# The Planning Inspectorate

### Application by Anglian Water for an Order Granting Development Consent for the Cambridge Waste Water Treatment Plant Relocation project

#### Procedural Decision

- Very low nutrient subsoil: extractable potassium: 0-60 mg/L (Olsen's method)
- Low nutrient subsoil: extractable potassium: 61-120 mg/L (Olsen's method)
- Moderate nutrient subsoil: extractable potassium: 121-180 mg/L (Olsen's method) / L

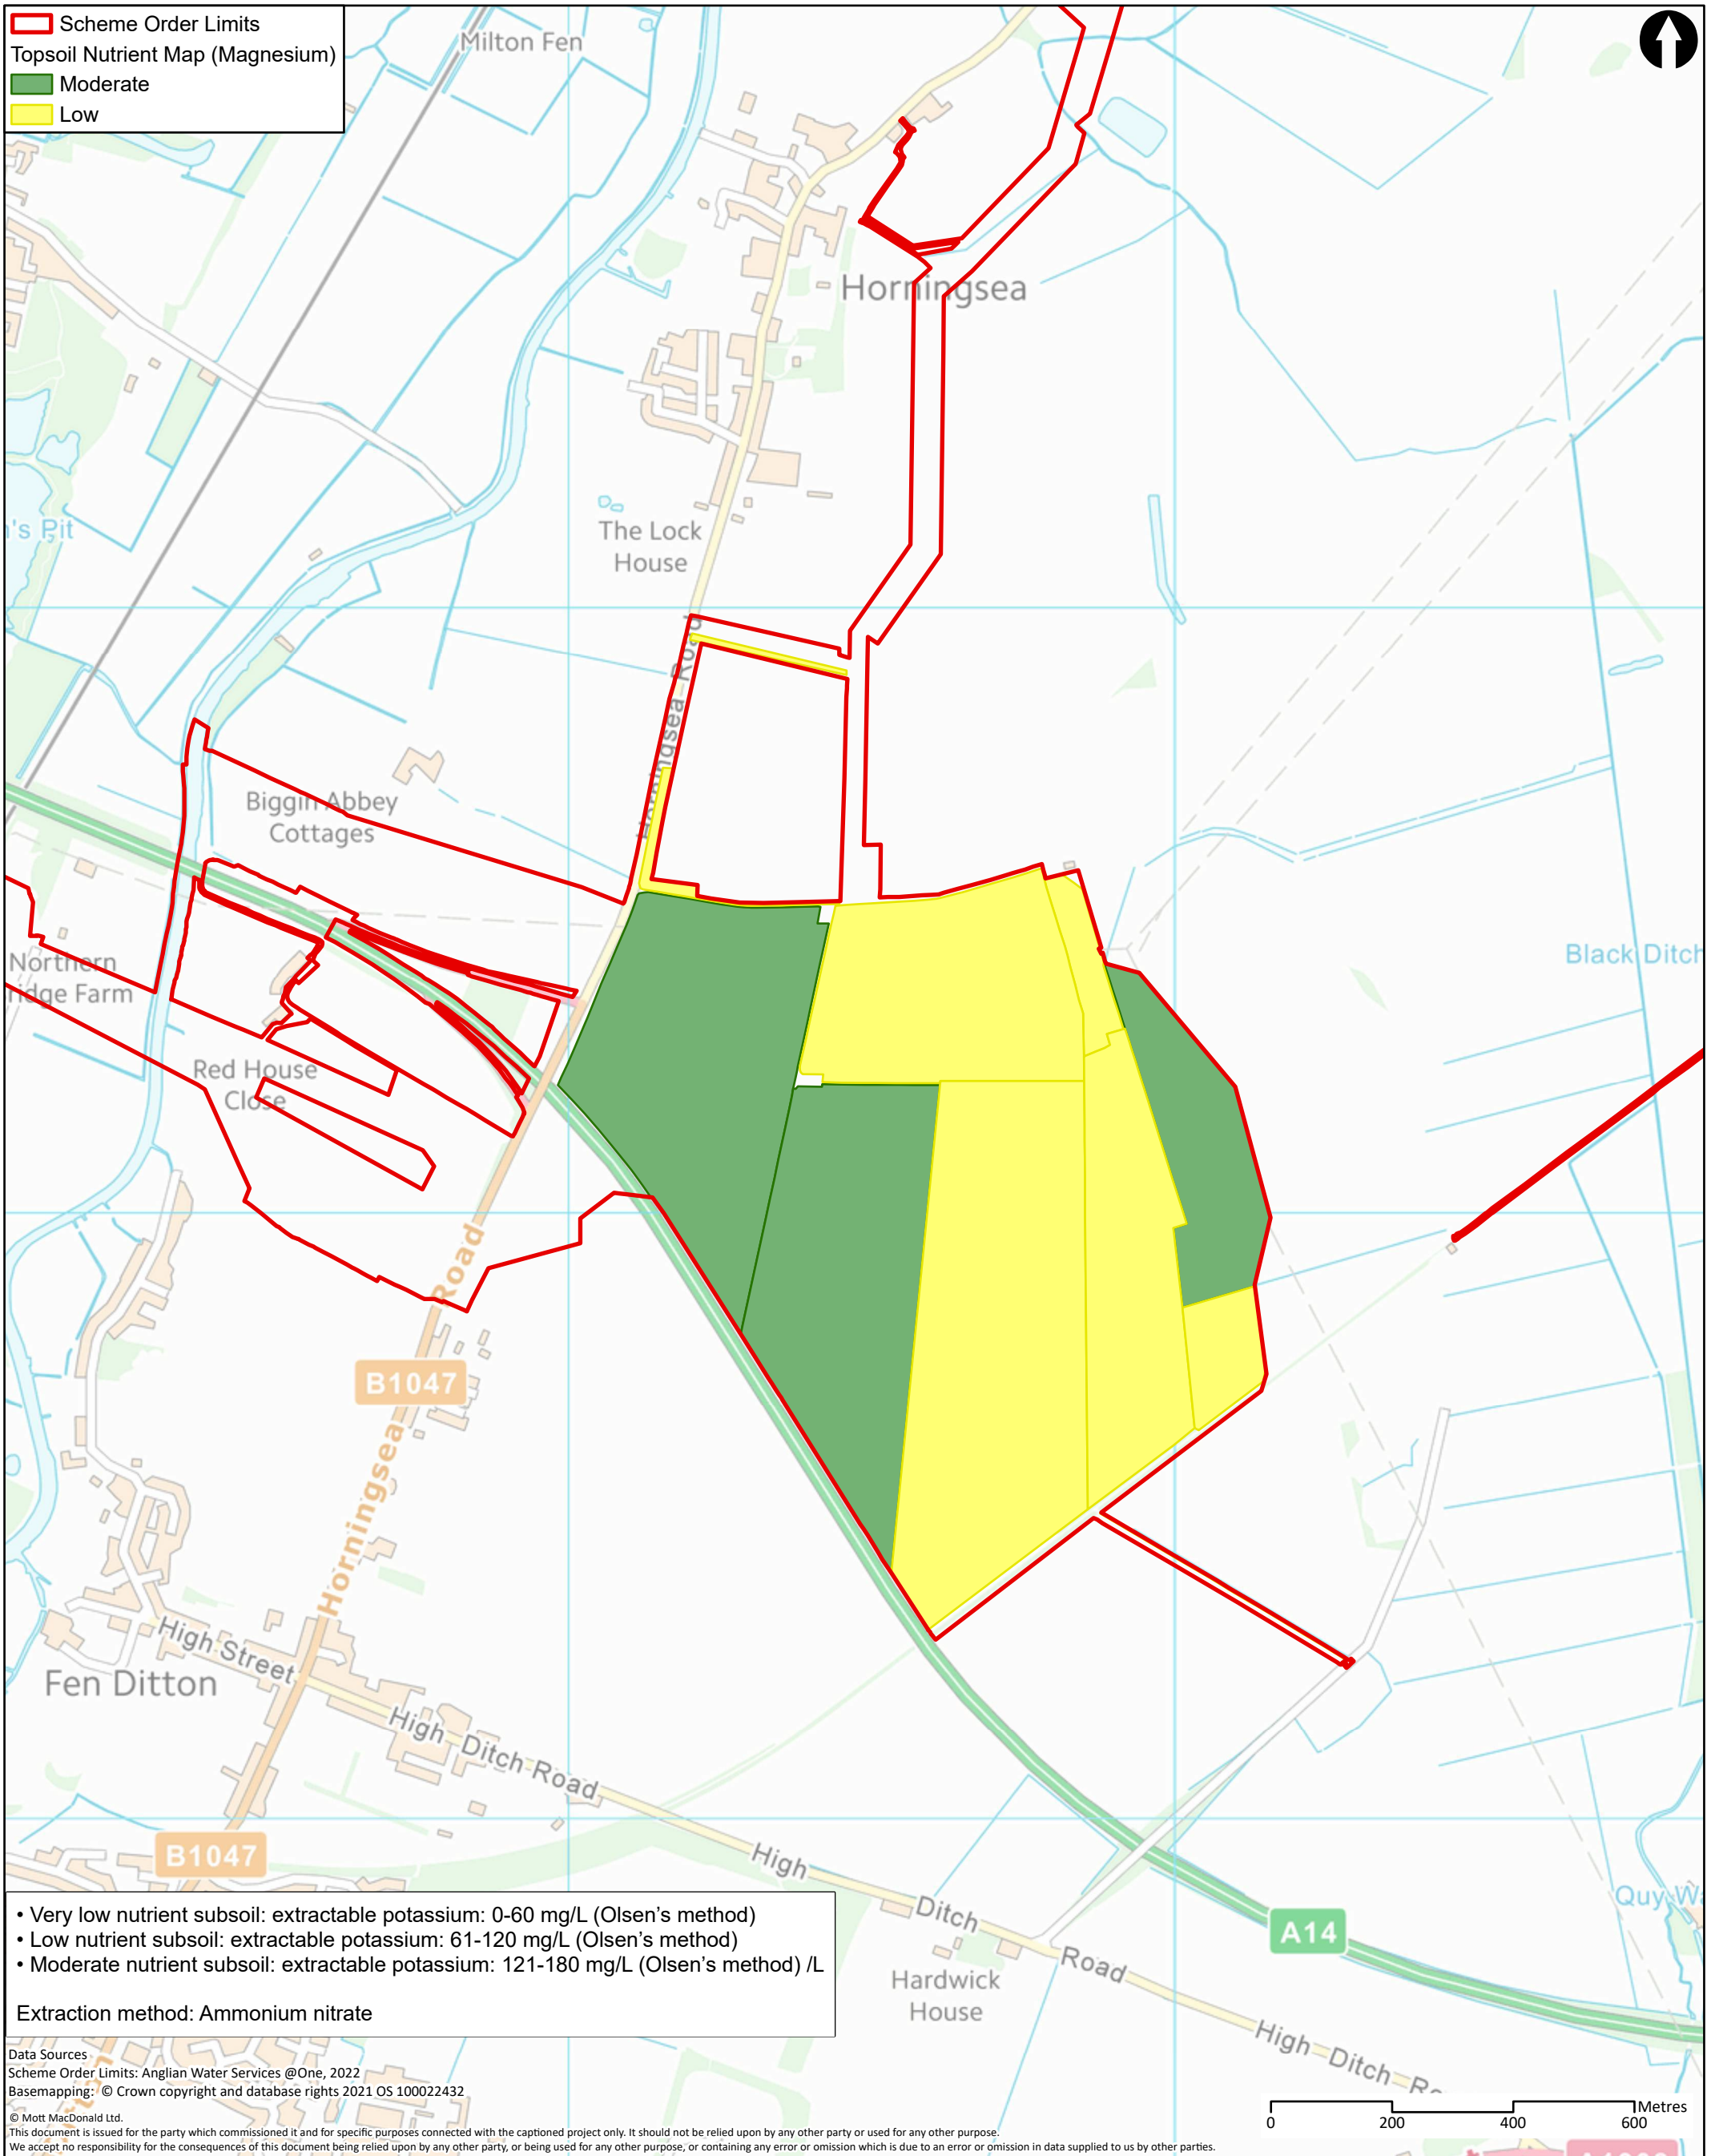
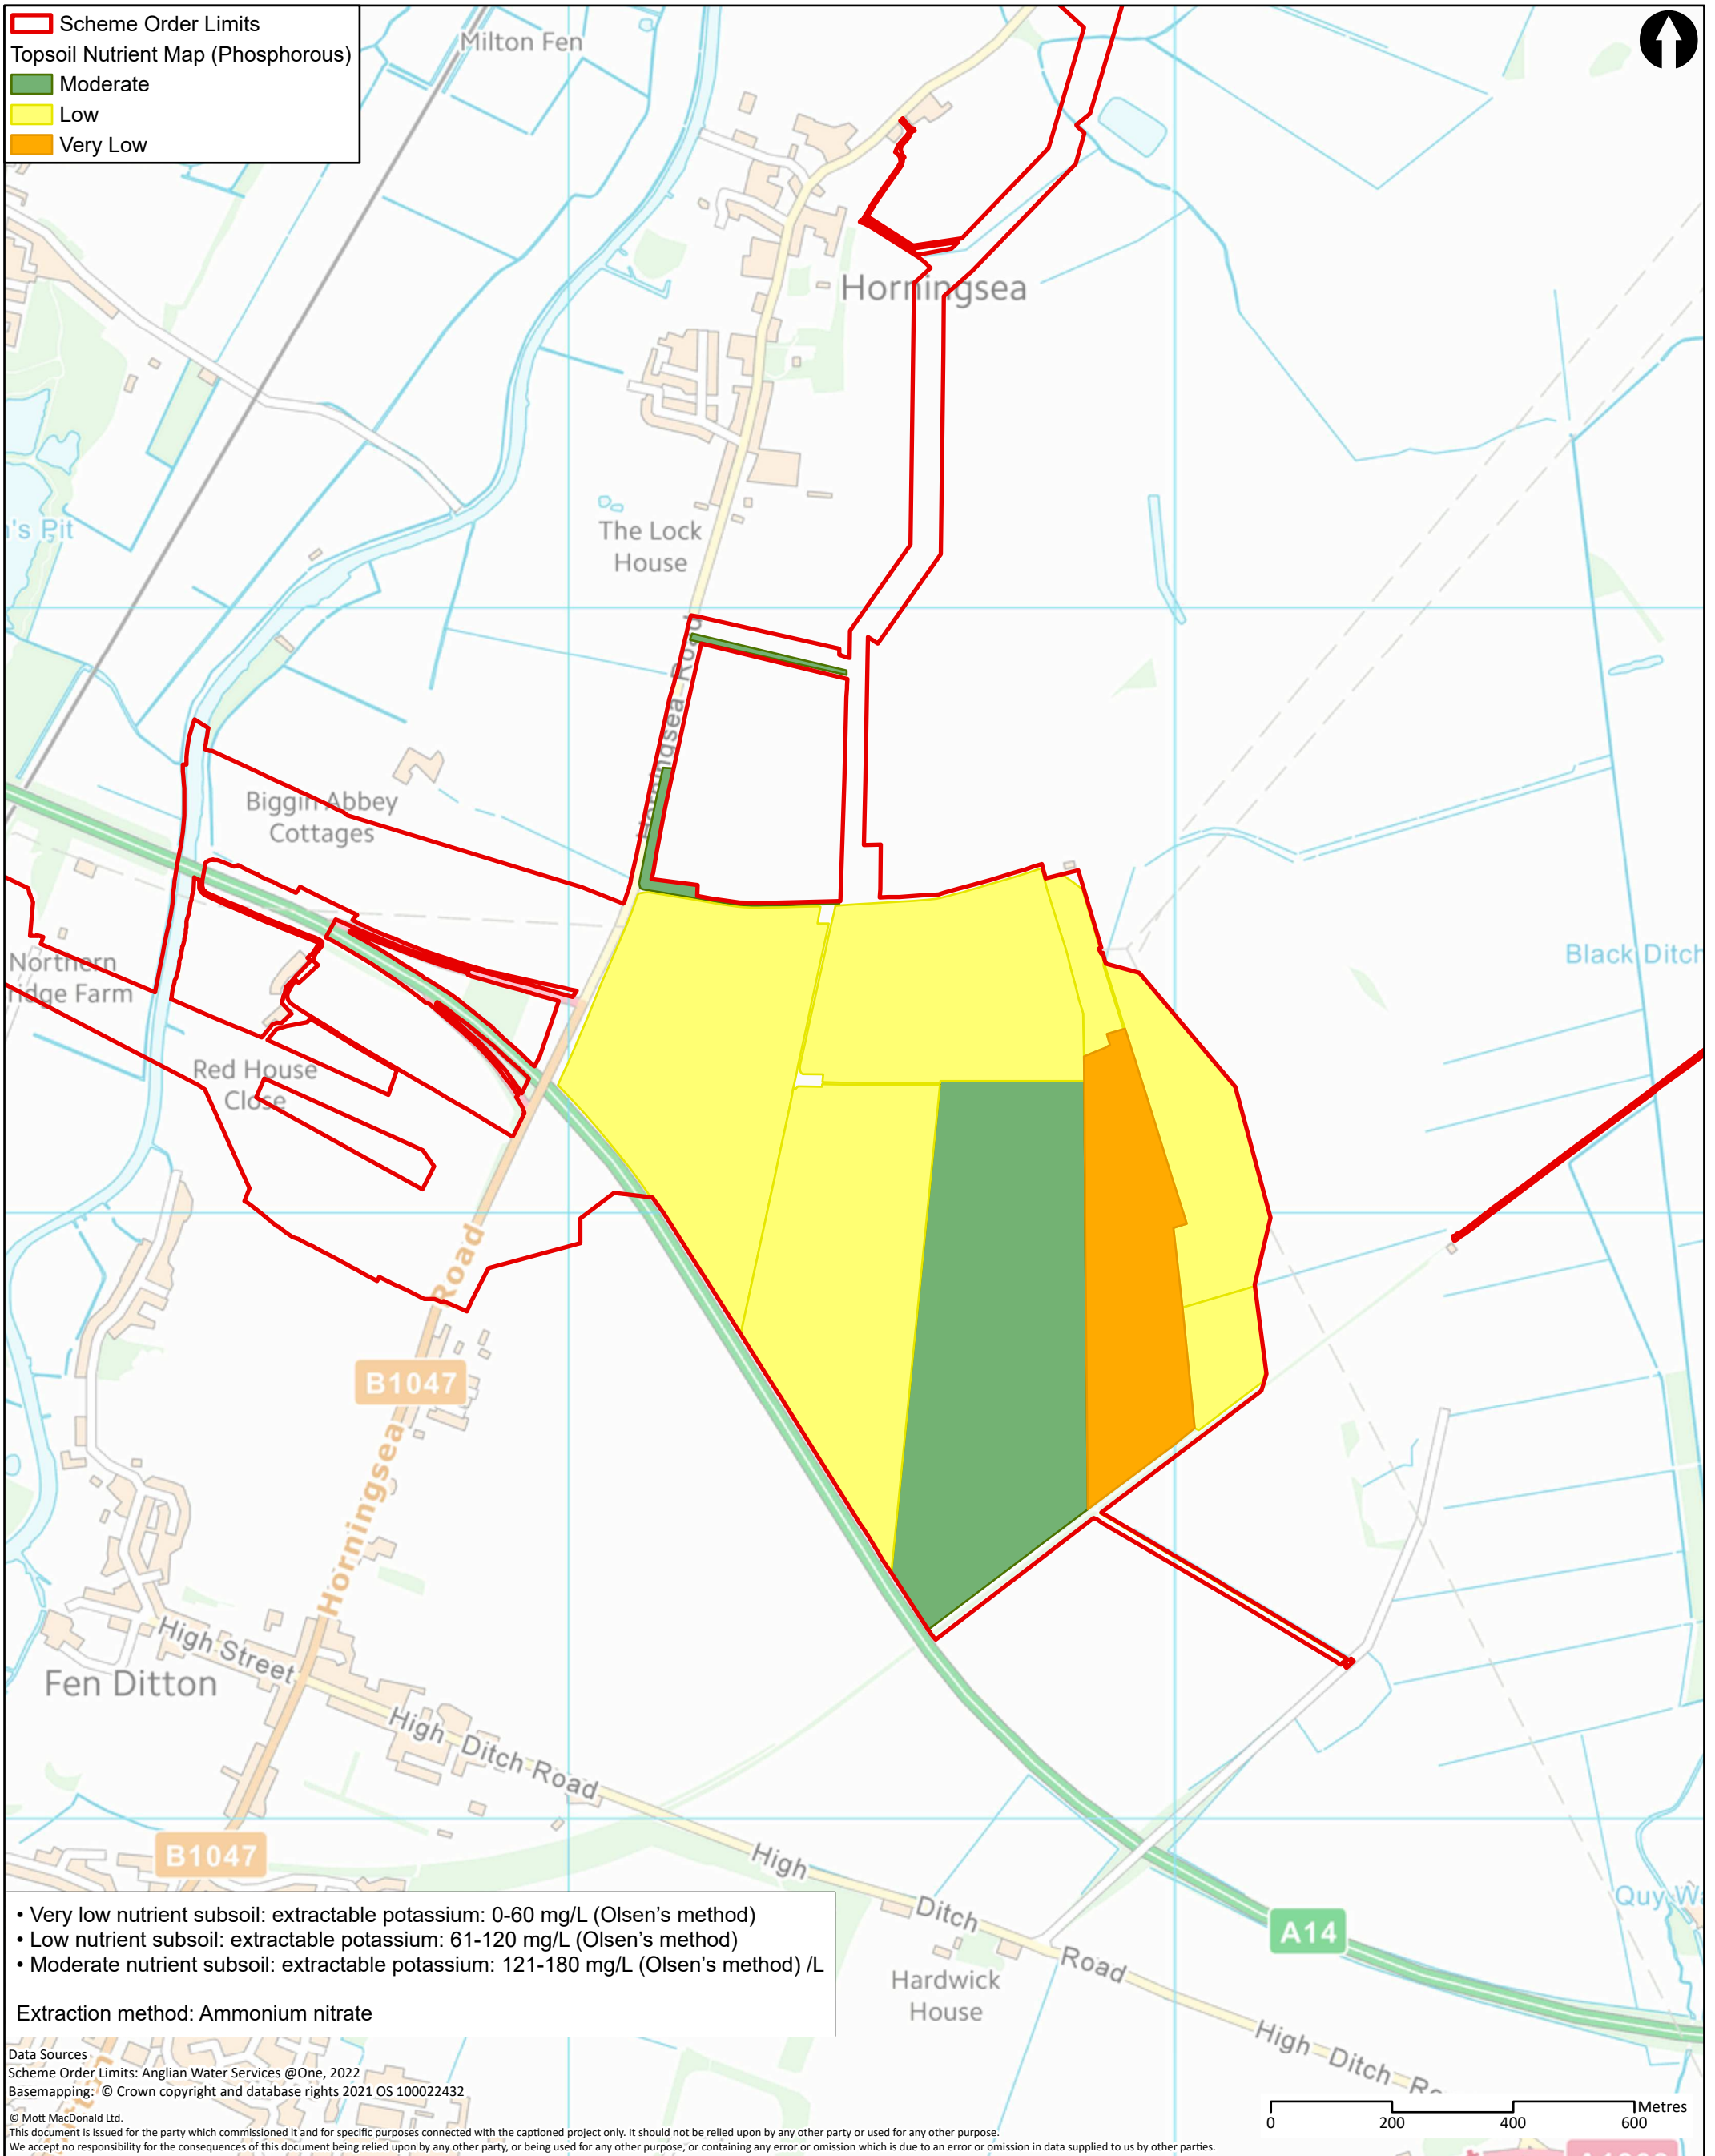
Incorrect information is presented in ES Figures 6.5, 6.6, 6.8 and 6.9, given that potassium ranges are displayed rather than magnesium and phosphorus ranges to which the figures relate. Please address.
